Cockle Bay Park – Response to Agency Submissions

Fire Safety Study

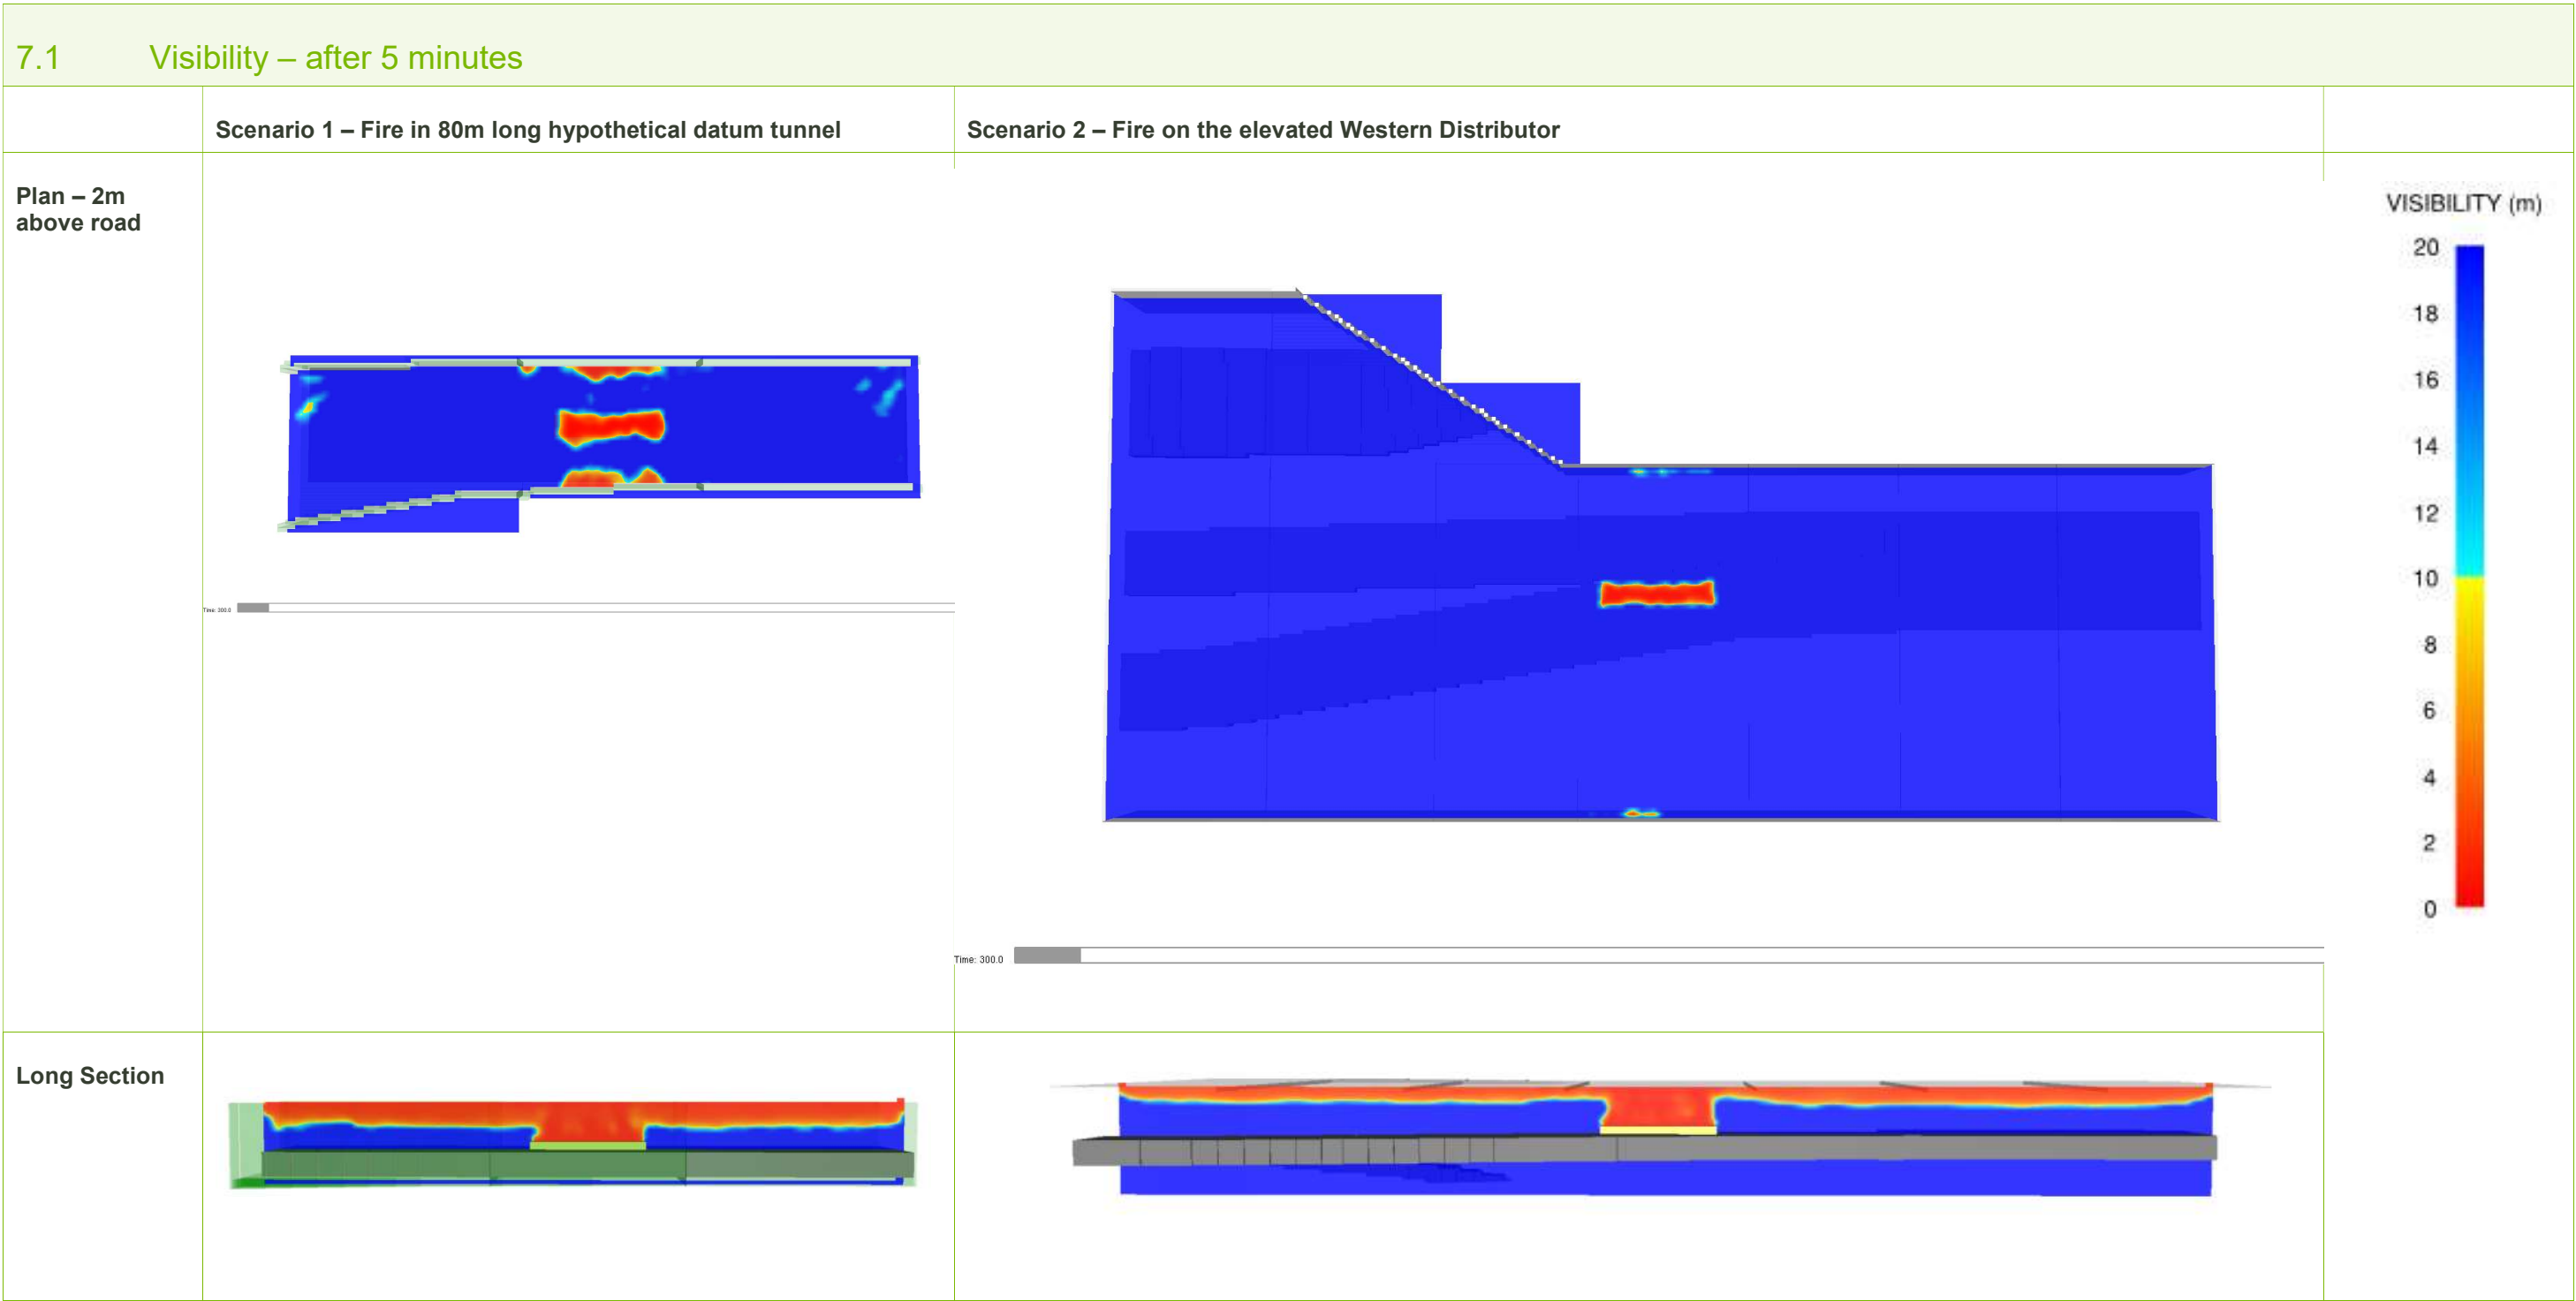
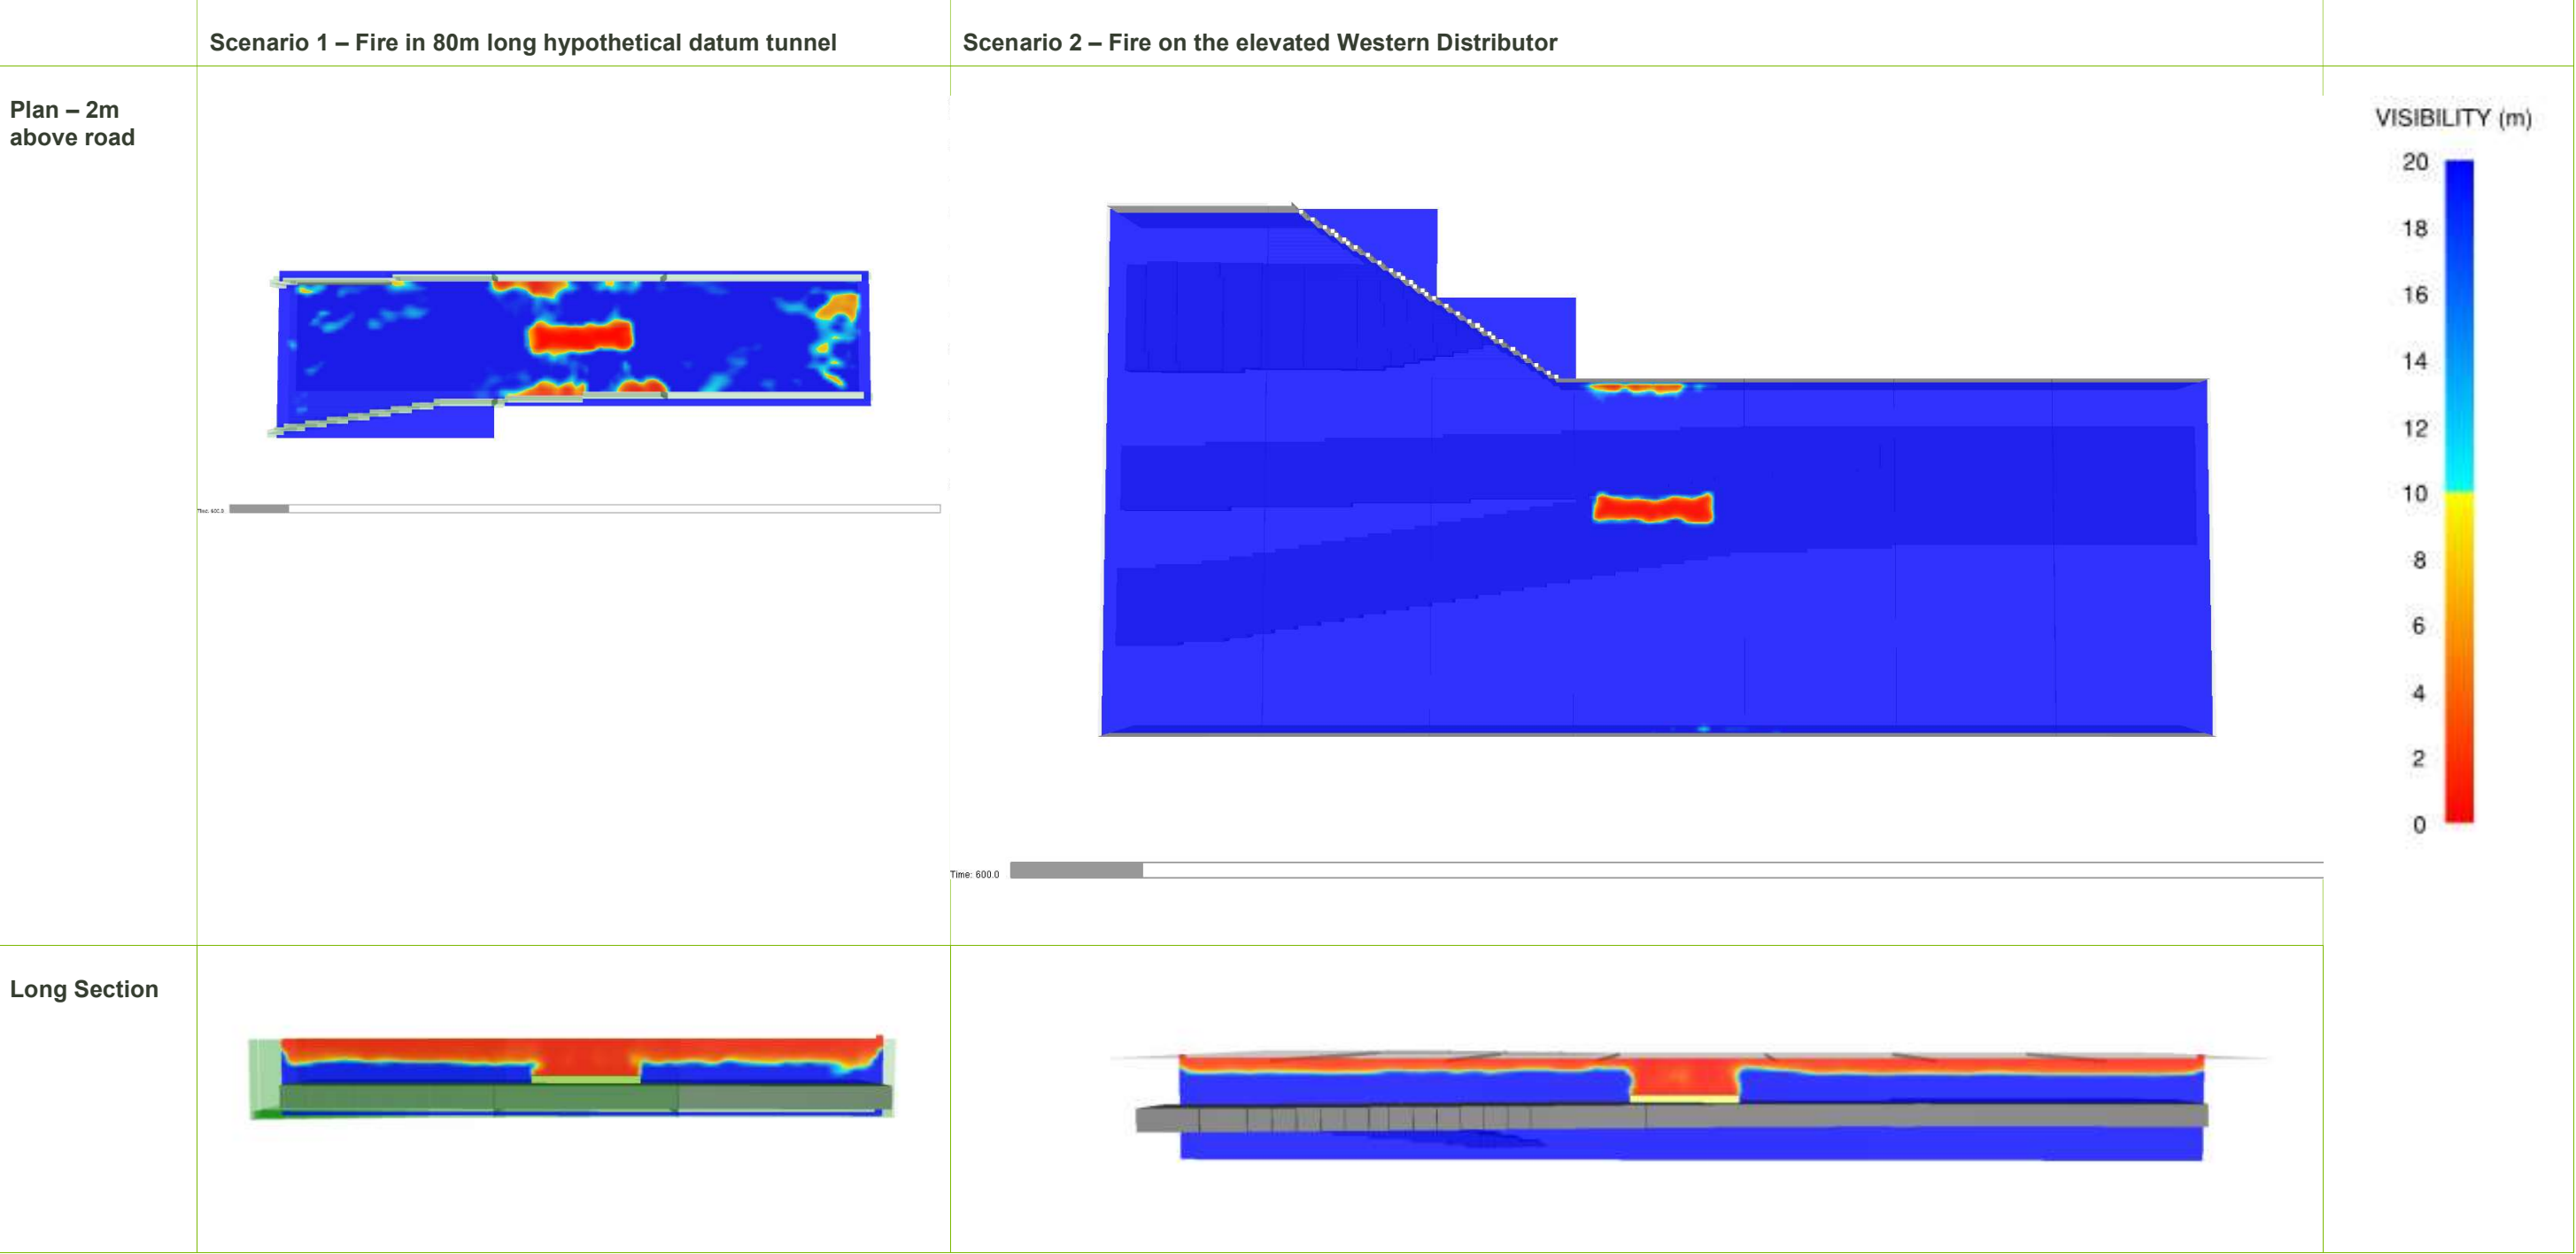
<p>Fire safety – the proposal has the effect of creating a tunnel underneath the podium – adequate provision of fire safety must be provided regarding traffic flow</p>	<p>Fire safety design criteria regarding the Western Distributor as it travels under the landbridge have been developed by Aurecon, in consultation with RMS (refer to Appendix J1). The design criteria are to be implemented at the relevant future stages of detailed design to ensure adequate fire safety provision is achieved.</p>
<p>Piering Options – RMS has request no piers in addition to the proposed piers option</p>	<p>Enstruct and Aurecon have considered structural options for landbridge pier locations including piers between on-grade northbound Harbour St and the elevated Western Distributor and an alternate 'no piers' option. The options are presented at Appendix K and Appendix W (refer to Section 7.20 of the</p>
